Project Name: 250 Canco Road
Address: 250 Canco Road
Applicant: City of Portland
Planner: Matthew Grooms

Project ID: 000008-2018
CBL: 148-A-008

PLAN CORRECTIONS REPORT PL-000008-2018 FOR CITY OF PORTLAND

TO: Matt Grooms, Planner
FROM: Lauren Swett, PE & Amy LeBel, EIT
DATE: April 13, 2018
RE: 250 Canco Road Level II Site Plan Application

**PEDESTRIAN WALK W/ CURB**

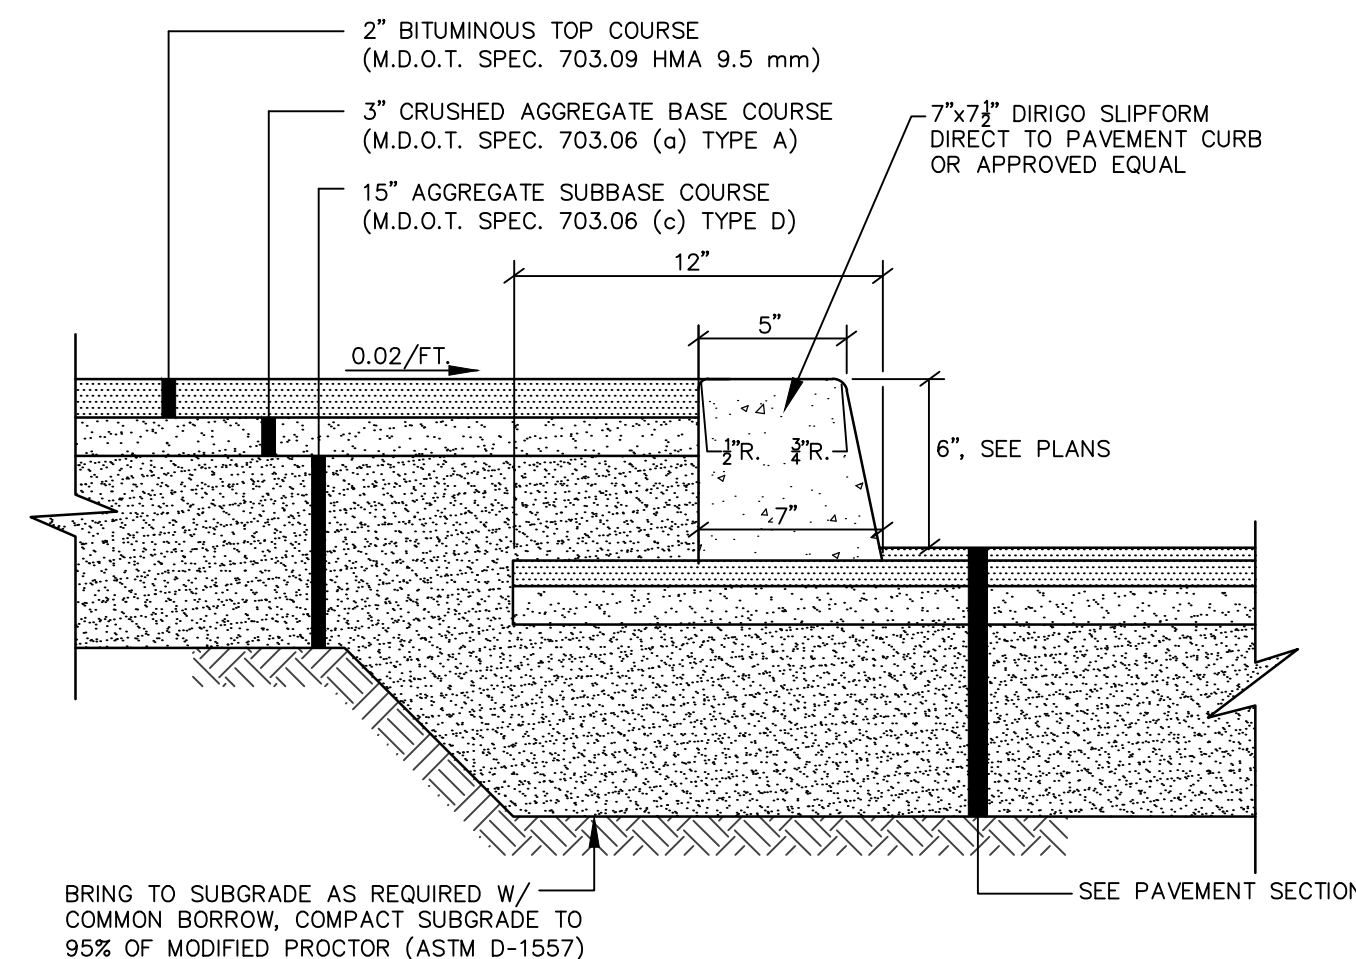
Comments: A continuous internal sidewalk shall be provided between the street and the existing sidewalk along the edge of the existing building.

Corrective Action: Update site plan and provide detail
